Application no: H16/0714/99

Description: Proposed dwelling with
swimming pool

Location: Plot Off The Beeches
Beechfield Gardens
Spalding
Lincs

NOTICE OF ACCEPTANCE OF AMENDMENT

### ELEVATIONS - JOINERY & LINTEL SCHEDULE

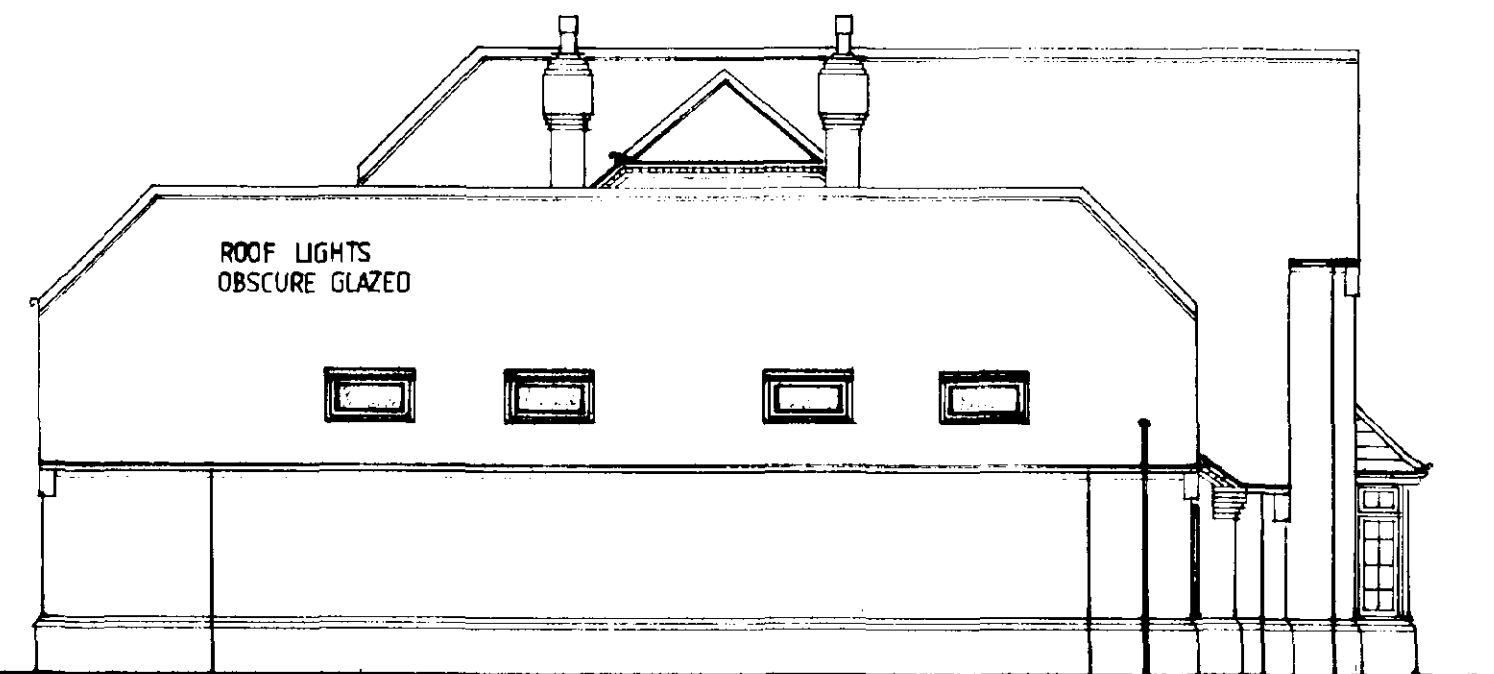
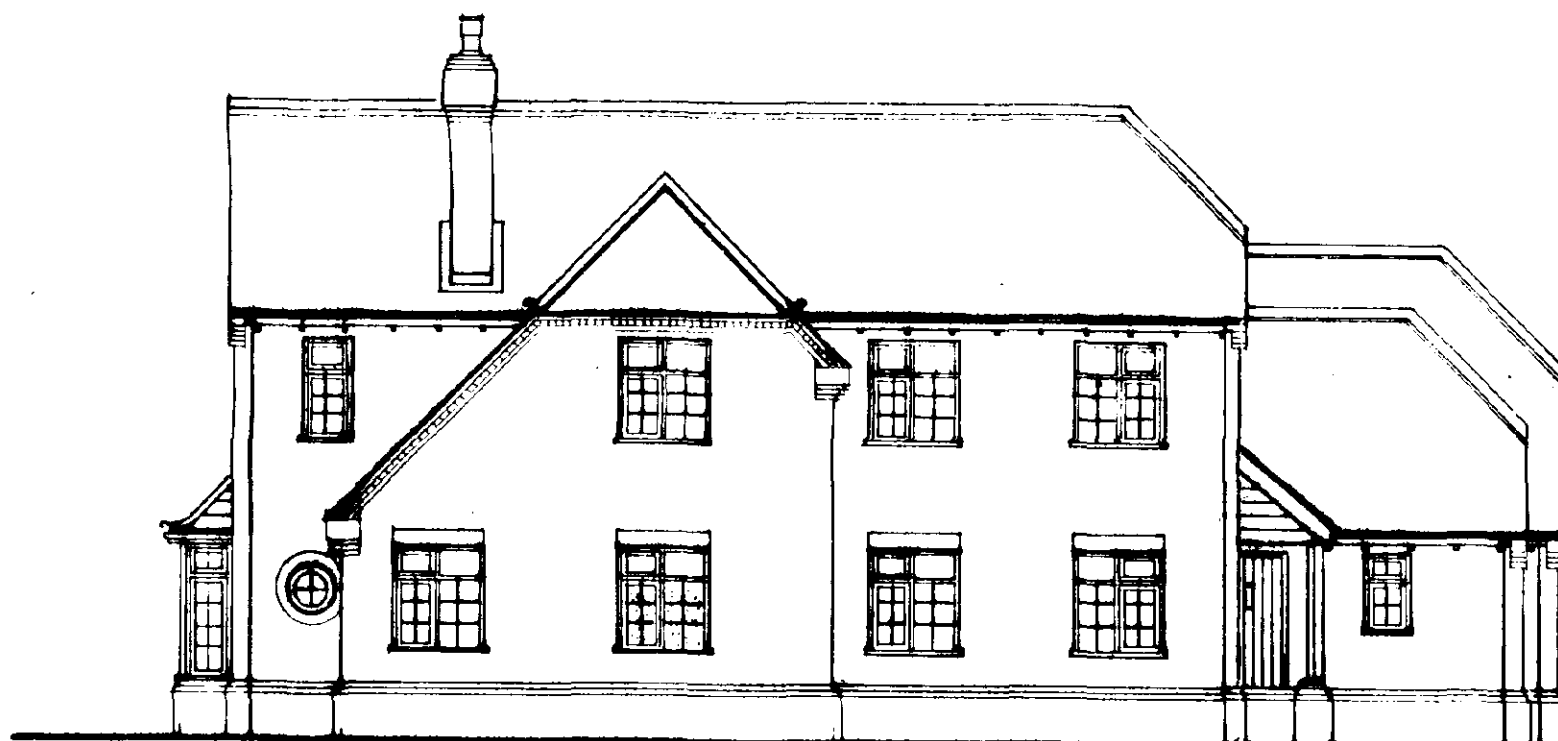
1. CORRUGATED BUNK TO GABLE VERGES IN LIEU OF BARGE BOARDS (ALL AREAS) ✓
2. 4 NO OBSCURE GLAZED ROOF LIGHTS ADDED TO NORTH ELEVATION. (IN SWIMMING POOL) ✓
3. 2 NO BUNK CHIMNEYS ADDED TO DWELLINGS. ✓
4. PERIMETER BUNK PLINTH ADDED (LOW LEVEL) ✓
5. SPLAY BAY WINDOW & ROOF TO LOUNGE IN LIEU OF SQUARE BAY WINDOW (WEST ELEVATION) ✓
